FAO: West Sussex County Council – Public Rights of Way

Planning Applications – P/30/26/OUT and P/31/26/OUT

26th May 2026

Appendix 1 – 05 May WSCC Public Rights of Way Letter

Ref:	WSCC/PROW/SP01
Date:	22.10.18
Rev:	C

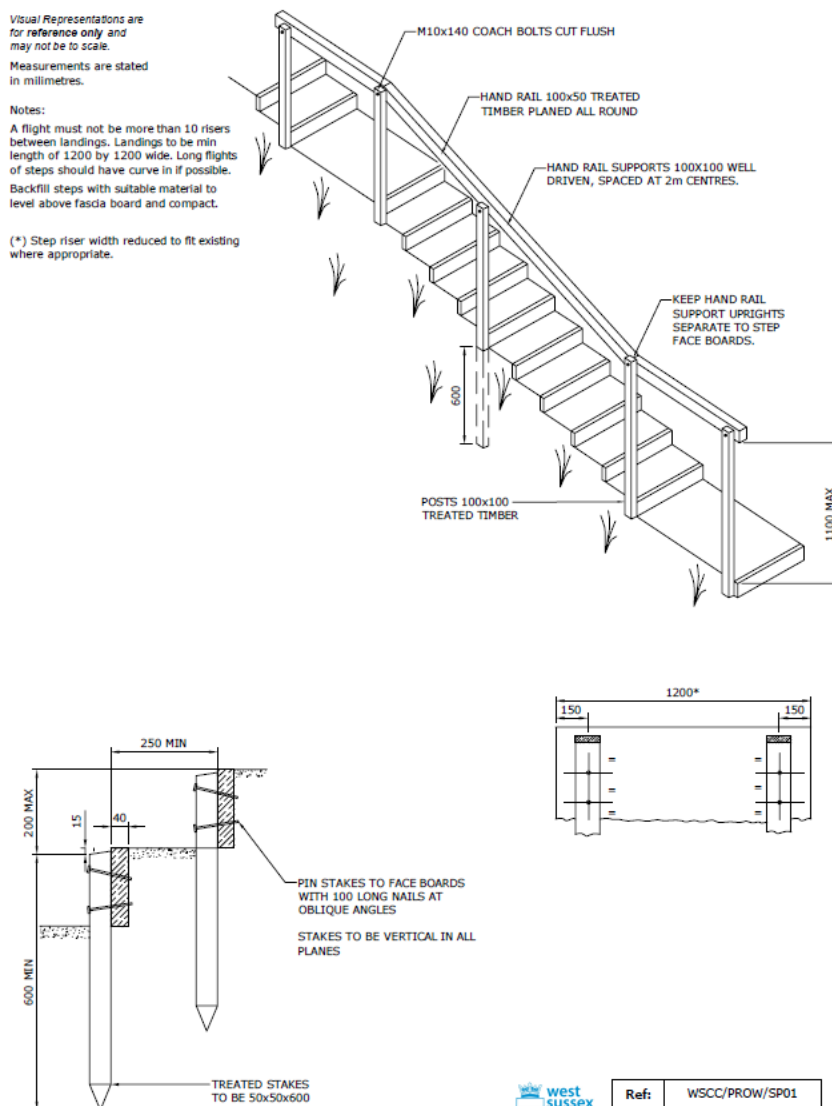
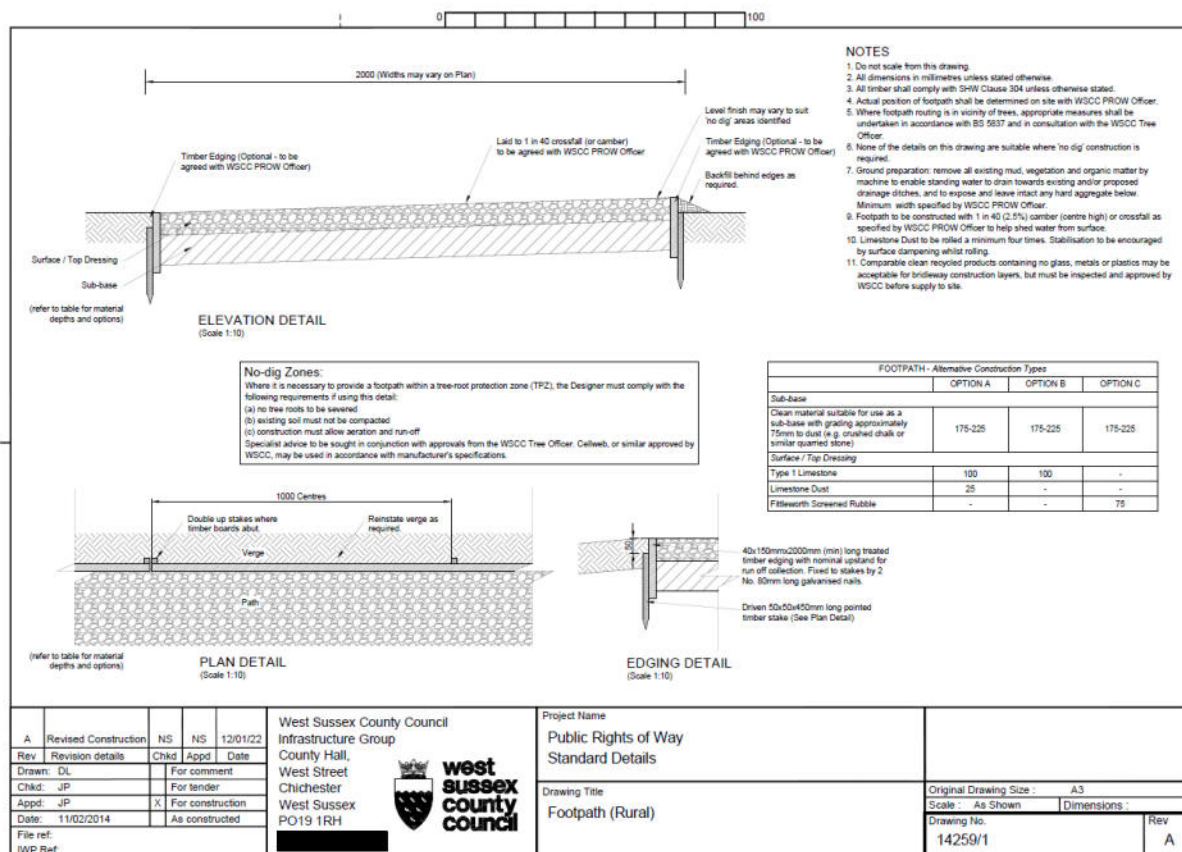
The stepped and ramped access from Summer Lane onto Footpath 108 is welcome. The ramp would not form part of the PRow so maintenance liability would remain that of the developer whereas the stepped access would be part of the PRow as it would be along the definitive line and provides sufficient access for pedestrians. I note the Safety Audit identifies the risk that the steps may lead to trips and falls and subsequent recommendation that corduroy tactile paving be used to highlight the steps. This is not necessary or acceptable and my objection is on this basis. Our standard step specification as shown below should be followed.

We are happy to agree that the stepped section of FP 108 will follow the WSCC standard step specification.

We are happy to agree that the surfacing of FP108 over the green sections (i.e. from Summer Lane north, upto the park home crossing point) will be to WSCC rural footpath specification, or a similar design to be agreed with WSCC at the reserved matters stage.
